Application No: WA/59/19/PL

Recommendation Report for Planning Permission

LOCATION: Pippins
Yapton Lane
Walberton
BN18 0AS

PROPOSAL: Provision of an additional 3 No. residential mobile homes. This application is a Departure from the Development Plan.

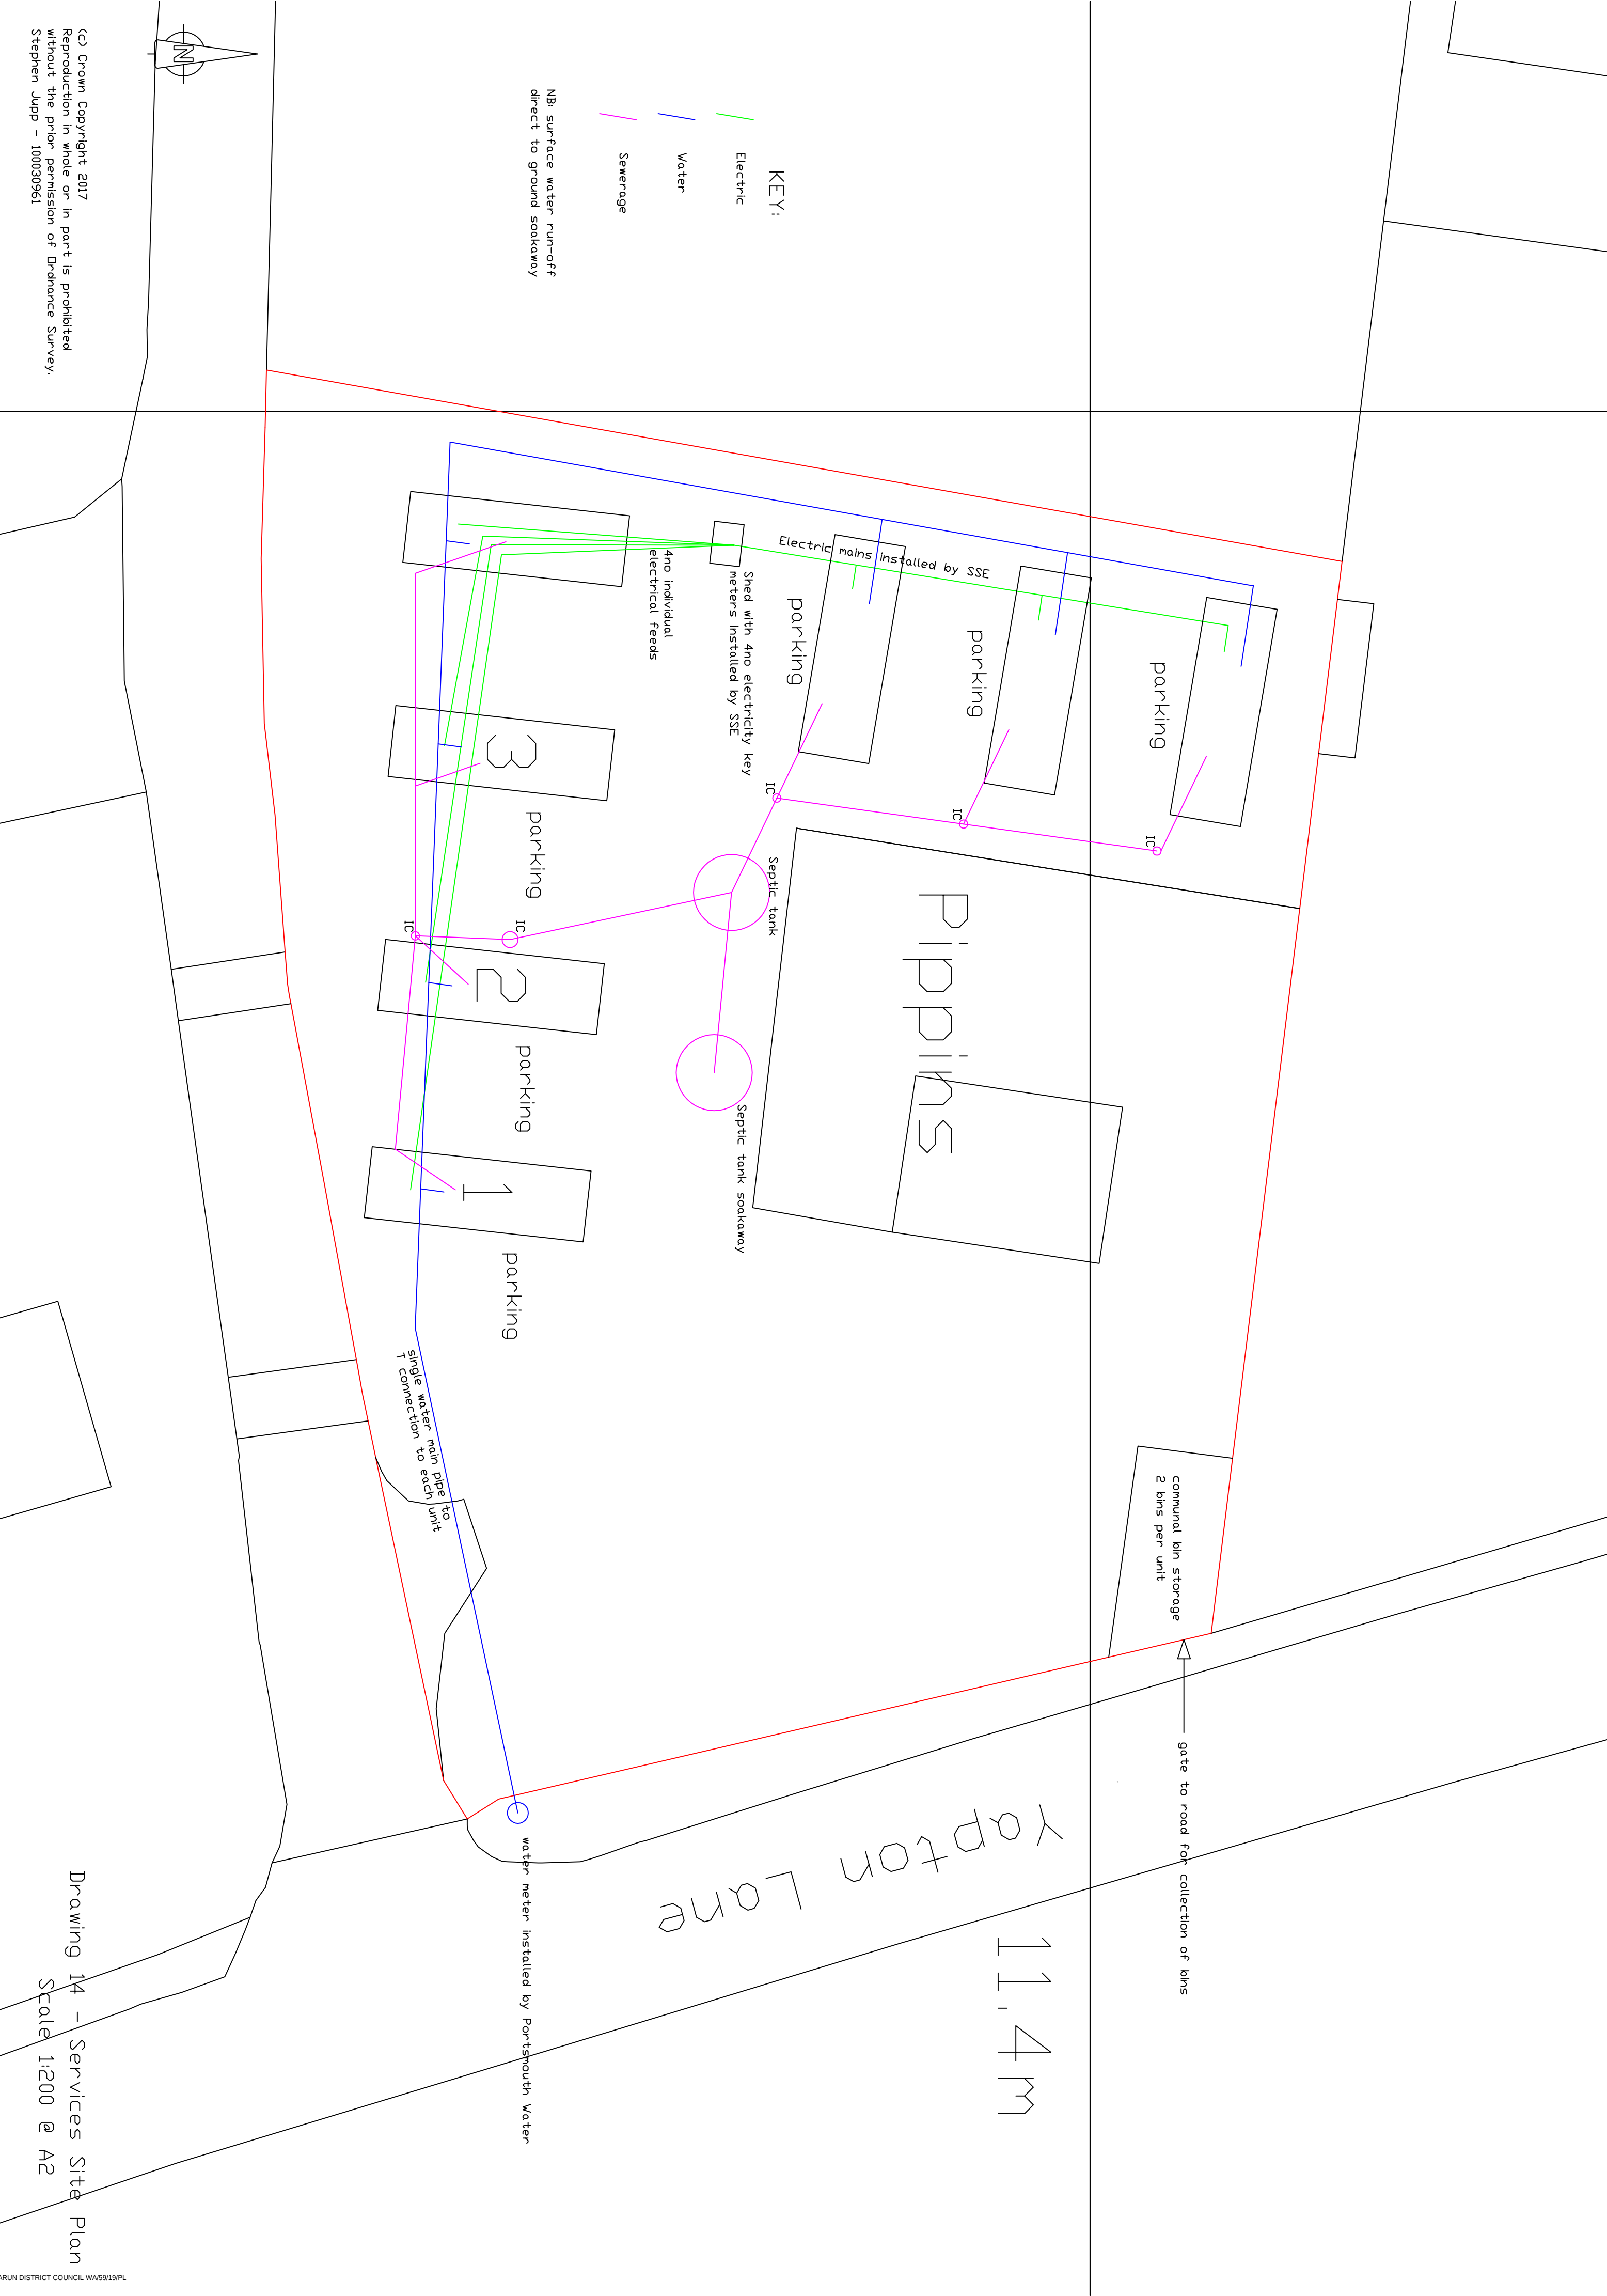
Inaccuracies in application form; existing housing states 3 x 2 bed homes, when there is a 4 bedroom detached property, and a fourth mobile home. Proposed housing states 6 x 3 bed homes, no reference to the 4 bedroom detached property or fourth mobile home. Site plan is unclear and does not clarify which have agricultural ties.
